Application Reference: 2025/0984

Site Address: 75 Rockingham Street, Barnsley, S71 1JS

Introduction: Erection of a two storey side extension, including under build to rear and the creation of a new access including dropped kerb

FRONT ELEVATION
SCALE 1:100

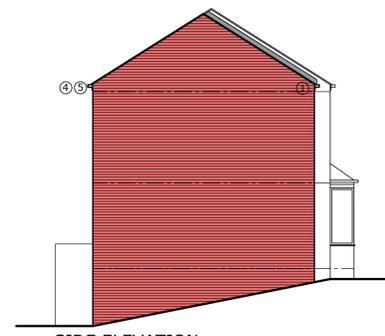
The proposed side extension provides a sideways projection of 3.2 metres. Given the existing dwelling is approximately 4.7 metres in width, 3.1 metres would be the ideal sideways projection at two thirds the width of the original dwelling as outlined within the House Extensions SPD. The proposed projection therefore exceeds this width, however by a nominal 0.1 metres. Given the proposal only slightly exceeds the two thirds width and the application is a resubmission of a previously approved scheme, the proposed 3.2 metre width is considered acceptable on this occasion.

The proposal has been set down from the existing ridge line and set back from the front elevation of the existing dwelling. This allows the proposal to remain subordinate to the dwelling and prevents a terraced effect to the street scene.

The proposed glazing matches the existing dwellings fenestration along with matching lintels and cills. The use of matching materials is welcomed and allows the proposal to remain in keeping with the character of the site and street scene.

SITE PLAN SCALE 1:100

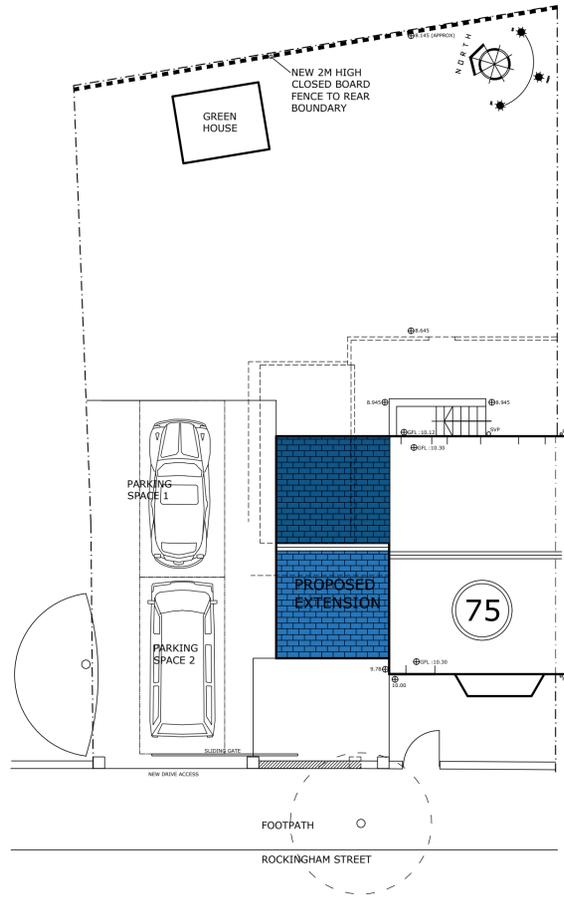
A newly formed driveway is detailed to the north of the proposed extension with an approximate length of 10 metres and an approximate width of 4.5 metres. A sliding gate is detailed to front the driveway, spanning approximately 4 metres and the existing driveway entrance is detailed to be replaced with a front wall with an approximate height of 0.9 metres and constructed from matching brickwork. A 2 metre high closed board fence is proposed to the rear boundary.

The proposed front wall has a modest height at approximately 0.9 metres and would be a matching continuation of the existing front wall. The proposed sliding gate would be located at a reduced height than the existing front wall it replaces and is therefore not considered to have any detrimental impact on the character of the street scene. The proposed rear fencing is detailed to be 2 metre in height and can therefore be erected under permitted development.

The existing onsite parking facility is detailed to be replaced by the proposed side extension with a new driveway located to the north of the proposal. Although the proposal increases the number of bedrooms from 2 to 3, the site maintains an acceptable amount of parking facility, providing 2 parking spaces.
